Revised 12/5/2022 - 3rd Review

RE: Vue De La Parc Apartments – Development Plan and Nonuse Variance – 3RD Review Comments

FILE: Application No. DEPN-22-0222

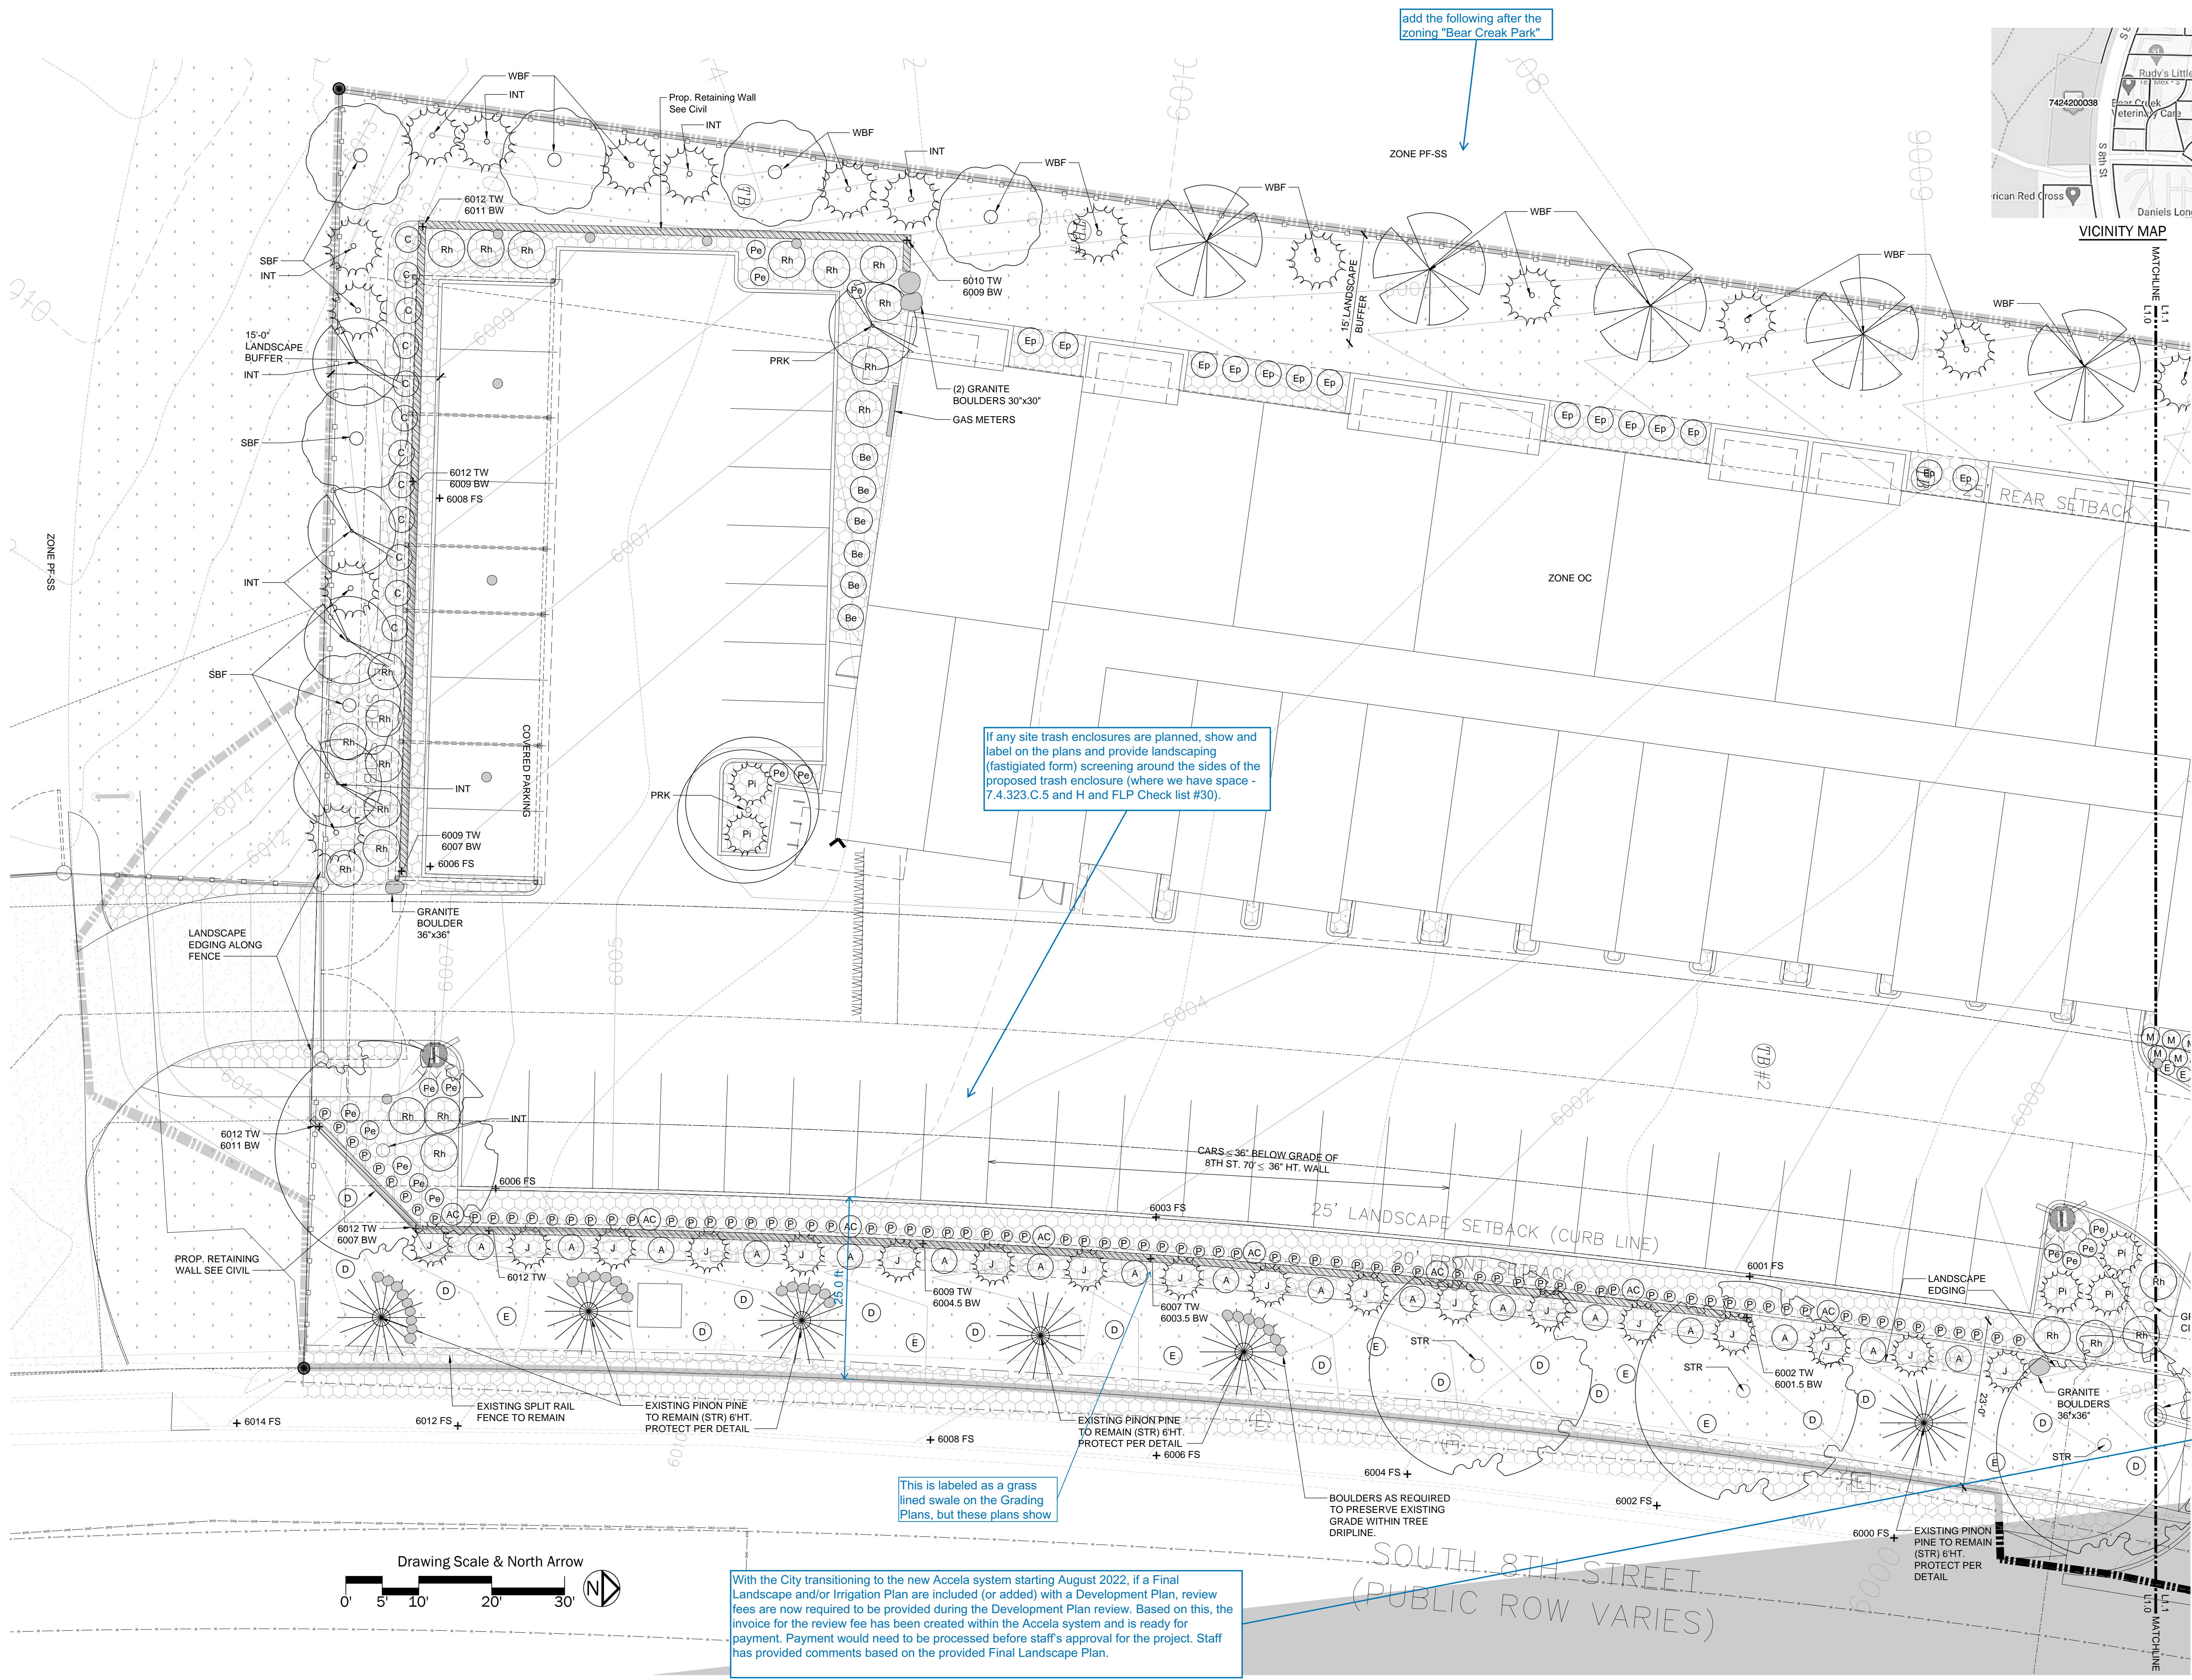
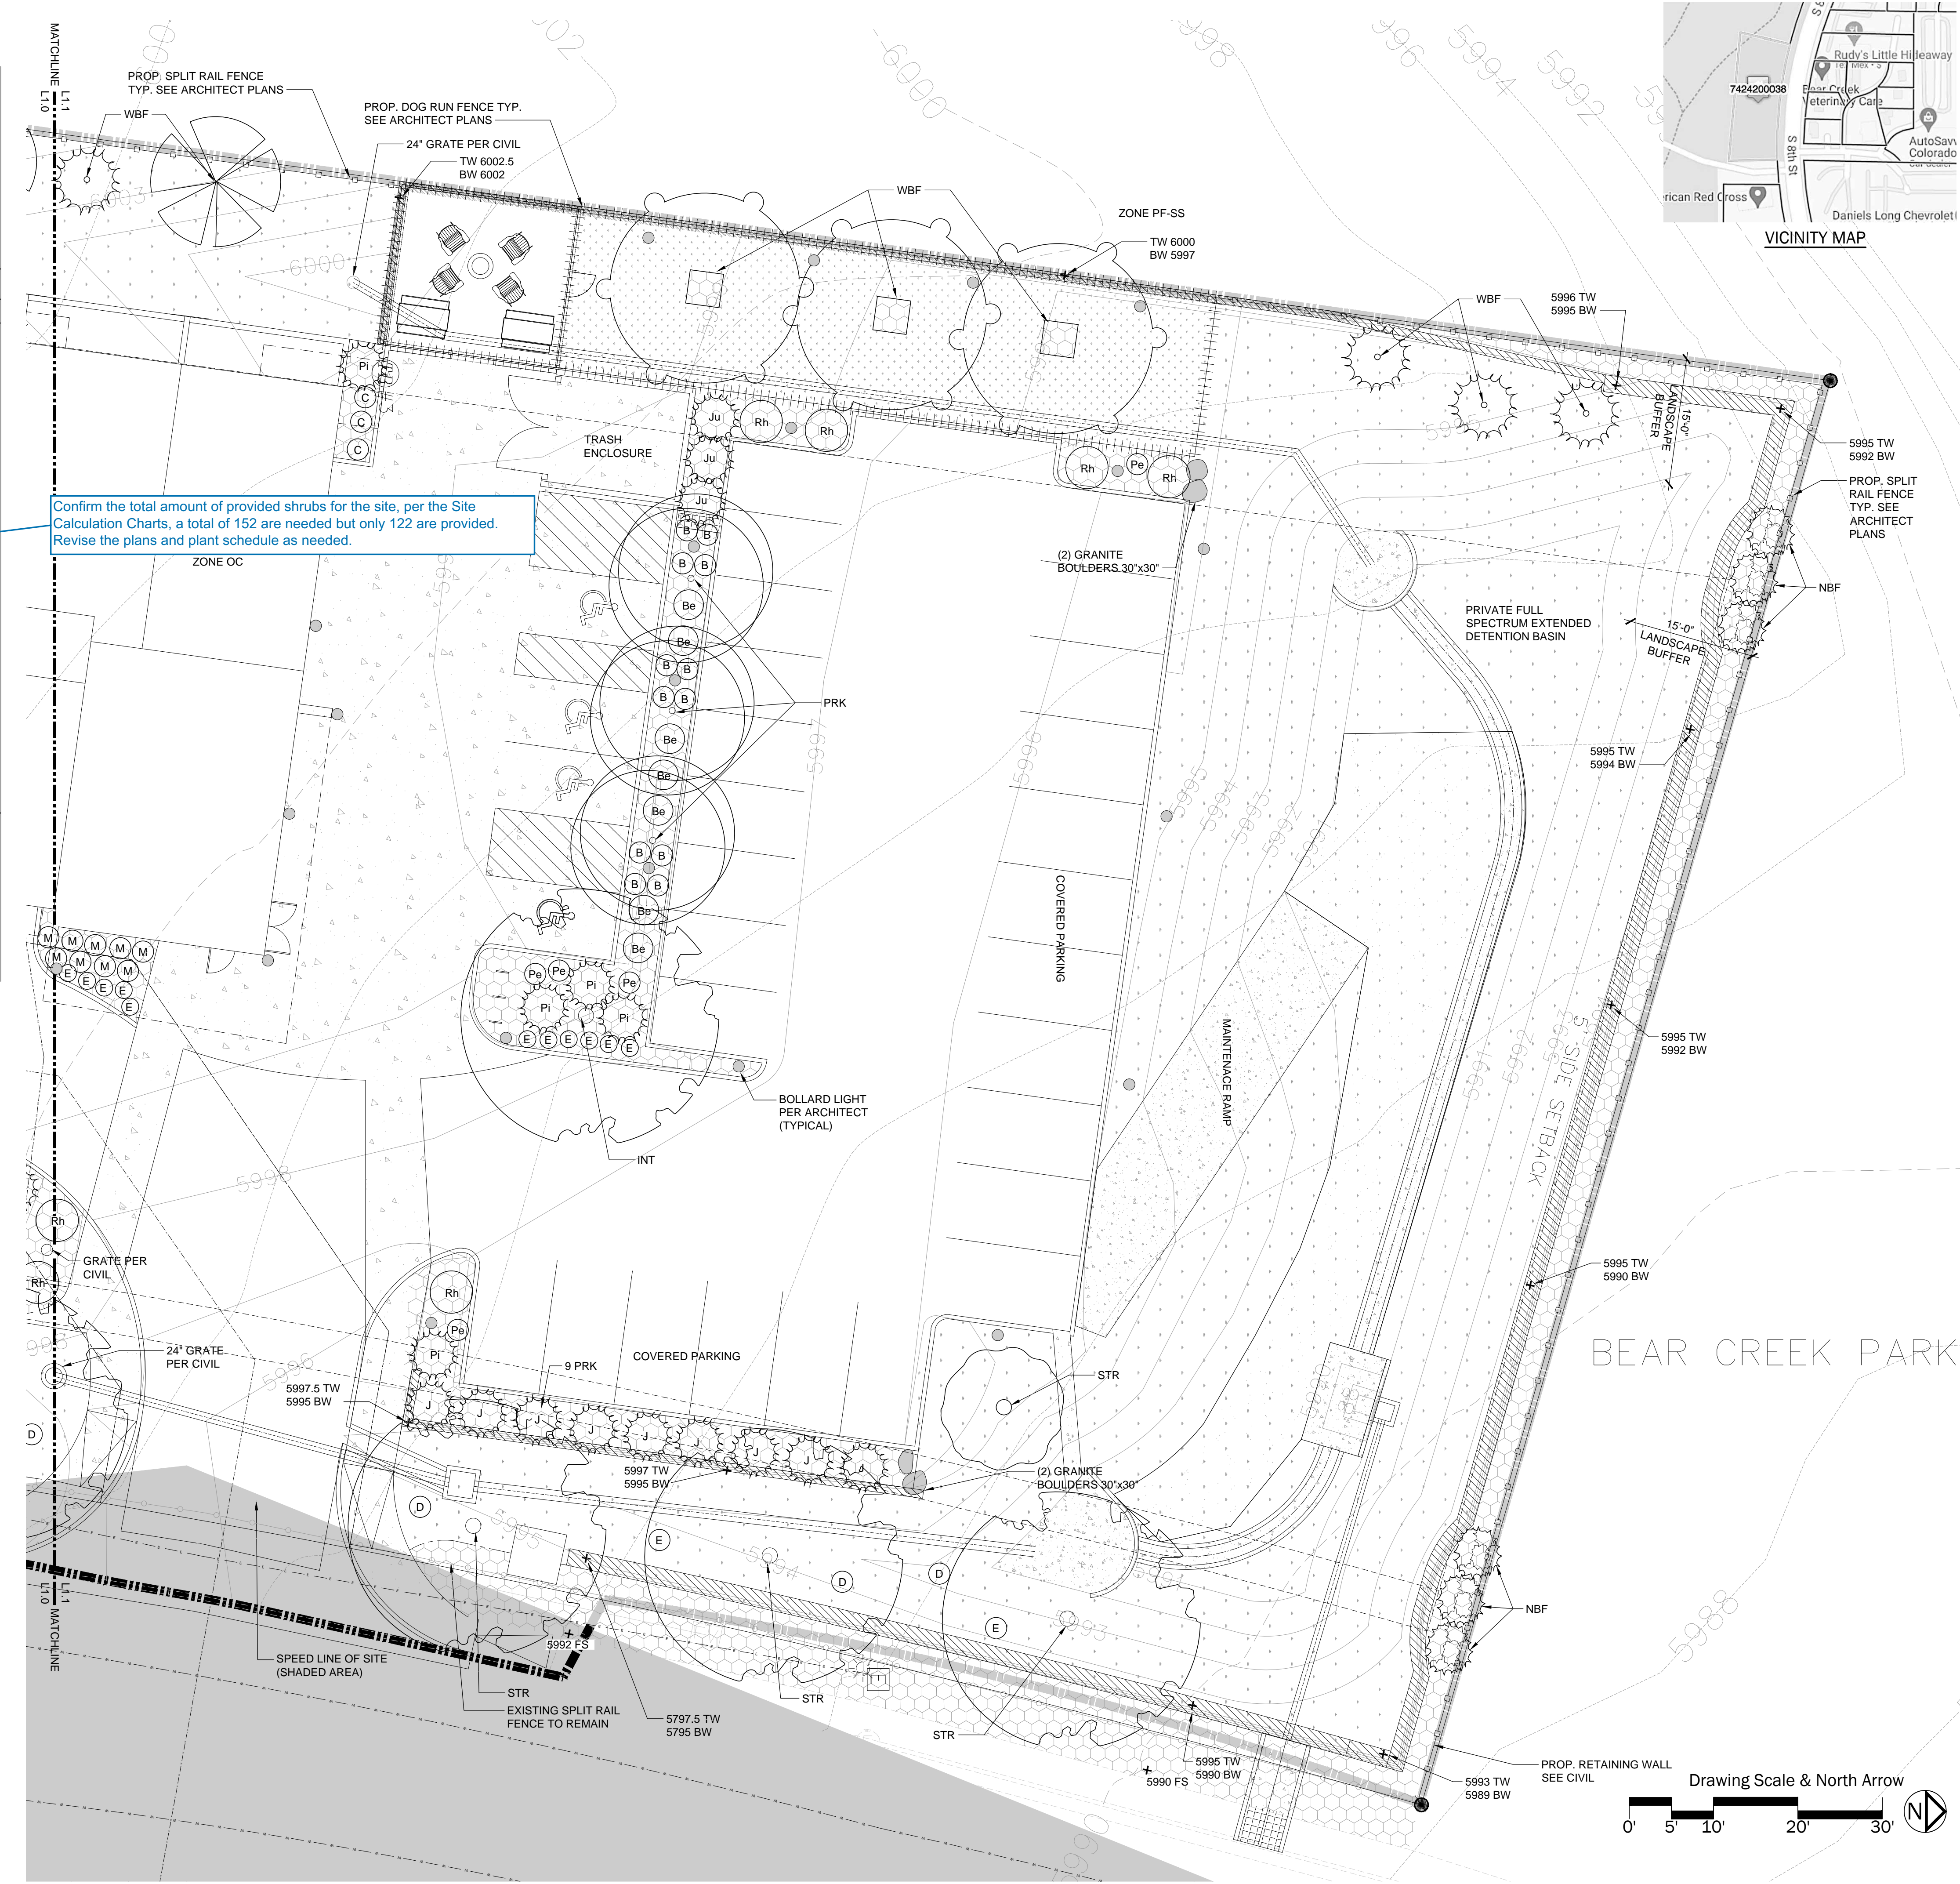
Add the following notes to this section:

"AN IRRIGATION PLAN SHALL BE SUBMITTED AND REVIEWED CONCURRENT WITH BUILDING PERMIT SUBMITTAL AND APPROVED PRIOR TO ISSUANCE OF A BUILDING PERMIT AND BEFORE ANY IRRIGATION

With the overall size of the project, the required existing soils analysis report will need be submitted with the Final Landscape Plan or at the latest with the irrigation plan. If the soils report will be submitted with the irrigation plan, update note 3 to read -"The required Soil Analysis Report is required to be submitted and approved with the Irrigation Plan submittal and before any landscape construction. This would include completing the soil sampling and submitting the samples to a soils lab for testing. A separate lab test report and soil preparation recommendations (amendment/fertilizer amounts and application rates) for each type of proposed landscaping (Shrub beds/Sod/Native Seed) will need to be provided to City Staff for review and approval." Soils test to be done after site grading per conversation with Daniel Gould

Update note 16 to include minimum amount of soil amendments for the native seed areas (2 CU per 1000 SF) This can be revised based on pending soils report. Addressed
